from
**Southern
Water**

Our ref
PLAN-036505

Proposal: Approval of details reserved by condition following Y/32/17/OUT relating to conditions 6-scheme to deal with the risks associated with contamination of site, 7-drainage strategy details, 8-surface water drainage scheme, 10-SuDS system, 19-lighting details & 23-details & timetable of decentralised & renewable or low carbon energy resources.

Site: Y/140/20/DOC: - Cinders Lane Nursery and Works to The Rear Cinders Lane, Yapton, BN18 0JJ.

HB1, Hydro Brake Manhole & Discharge from Sub Base Attenuation Details

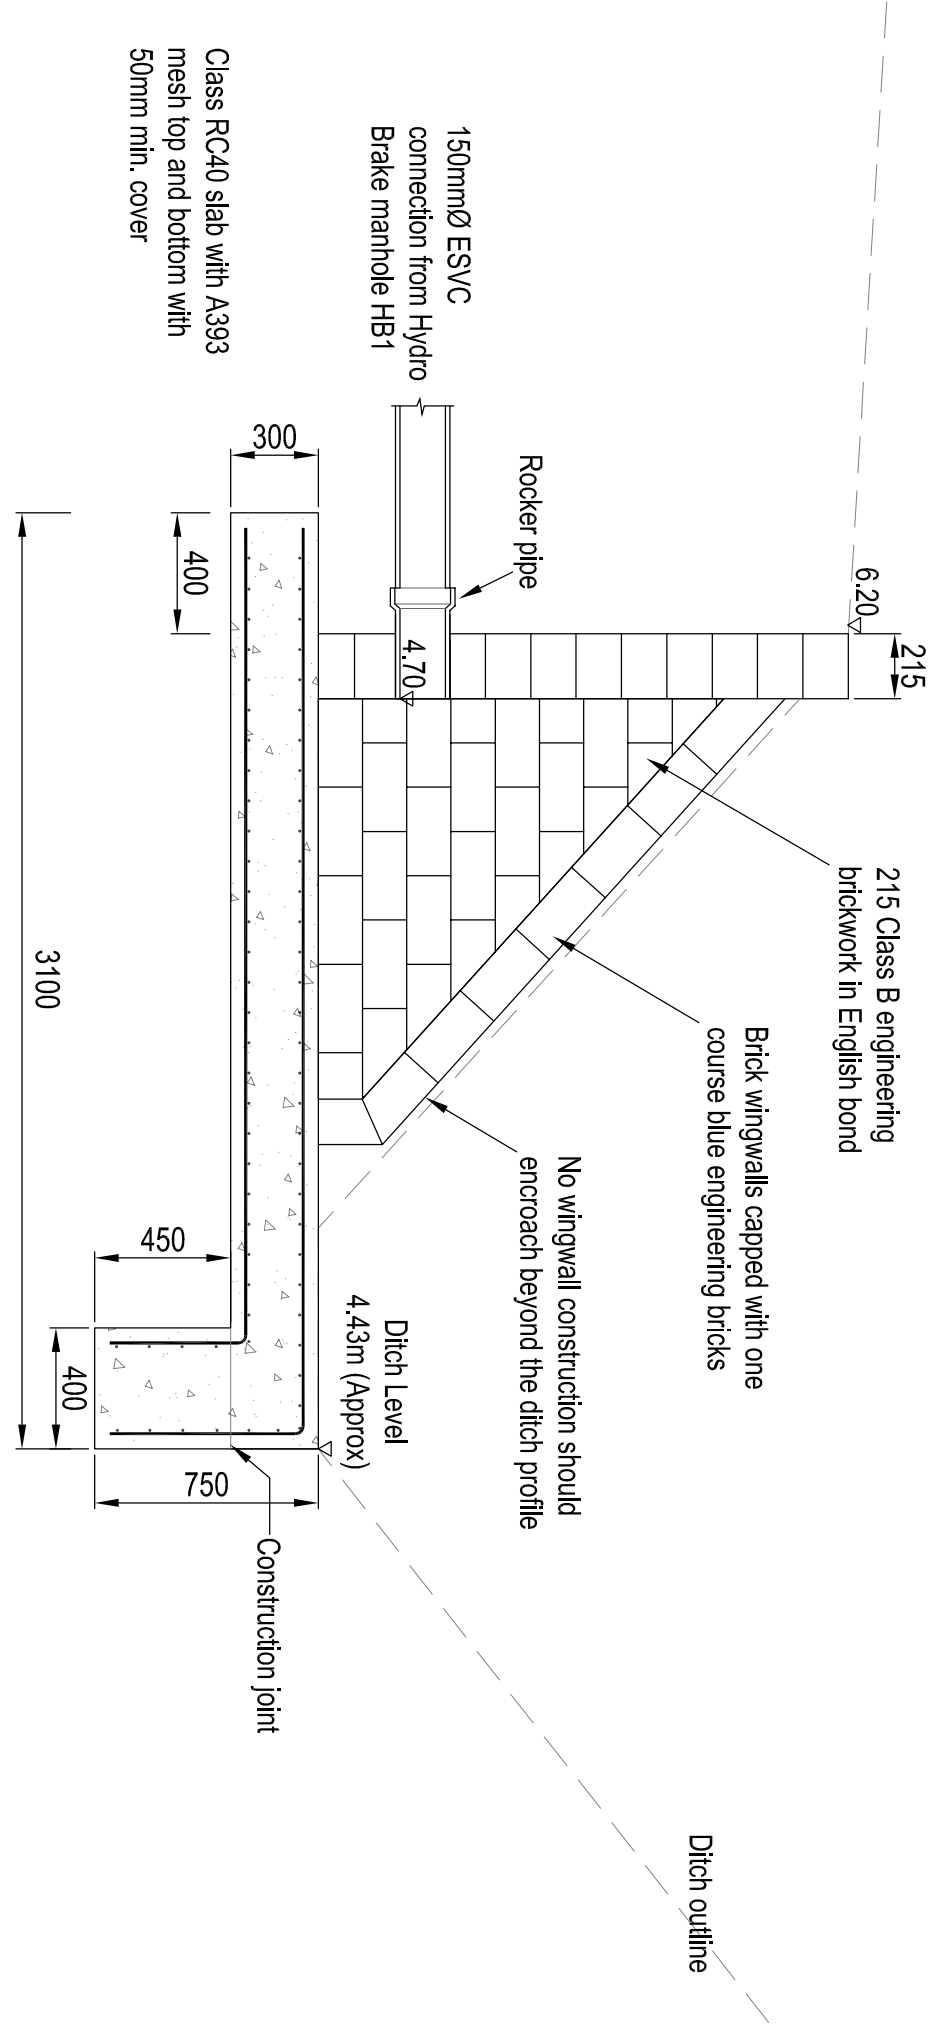
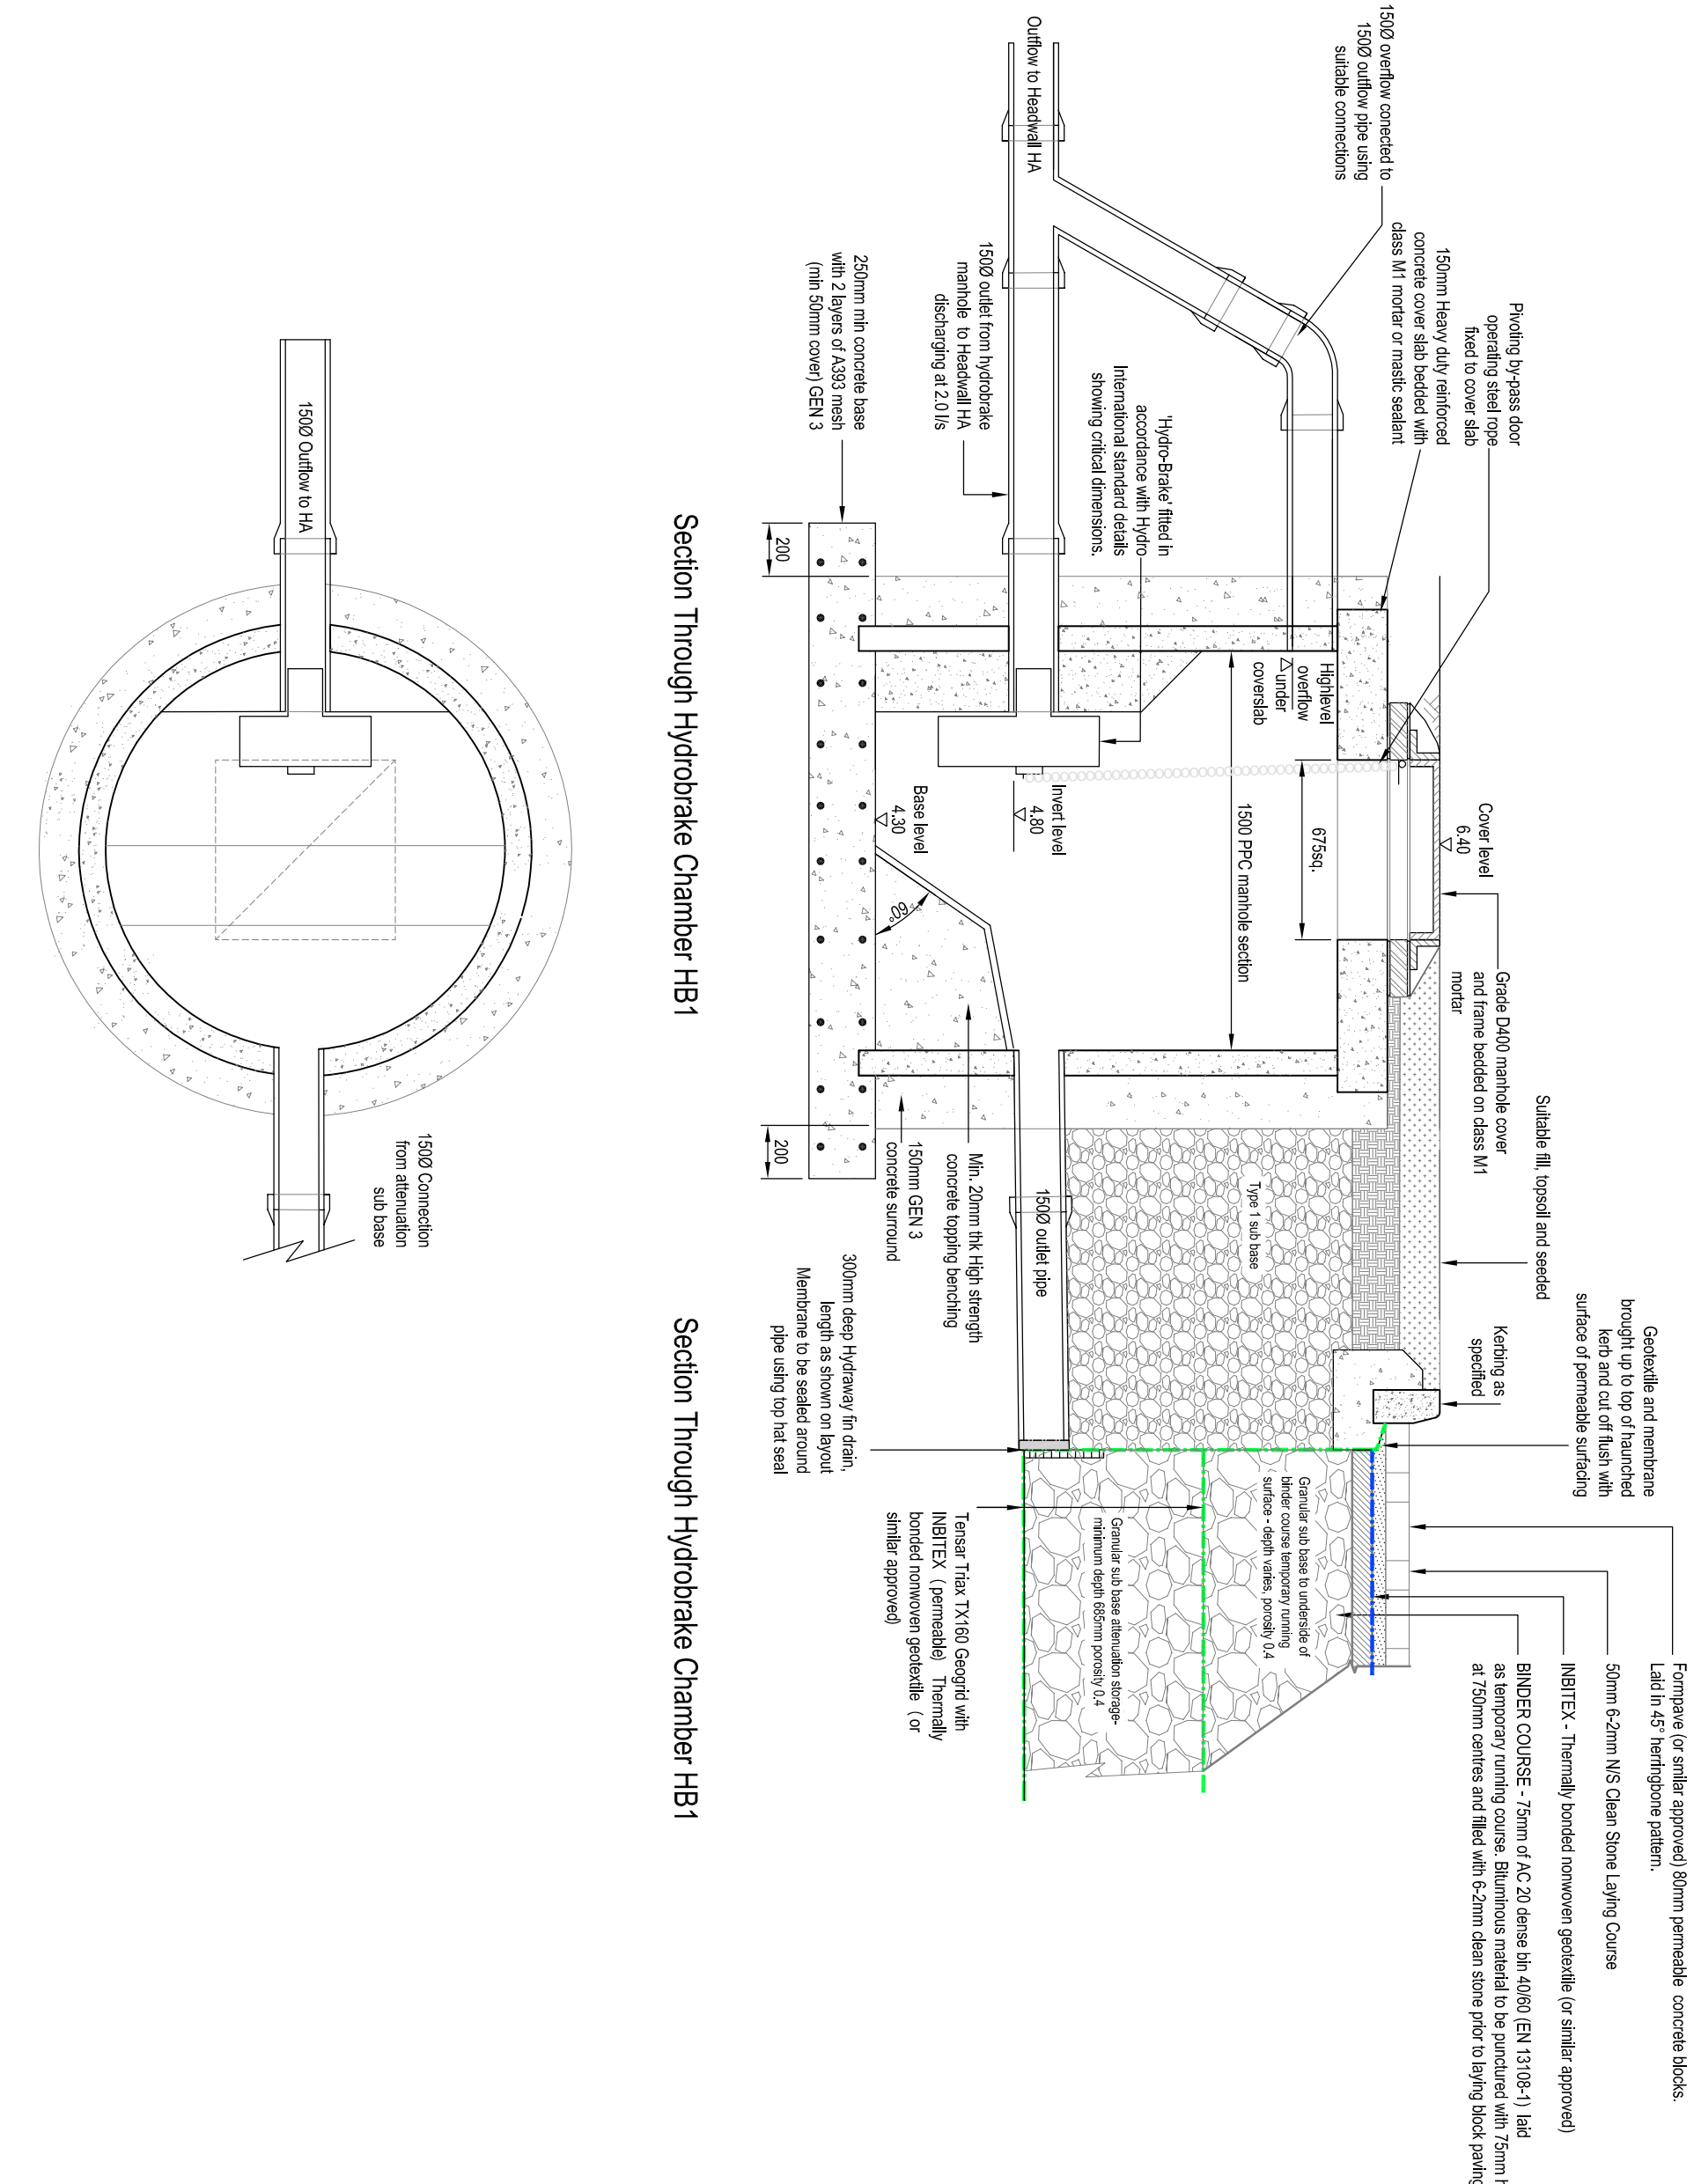
The proposed storage should be designed to be self-cleansing to prevent settlement of solids, we would recommend online storage in oversize pipes or additional storage discharging direct to the pumping station.
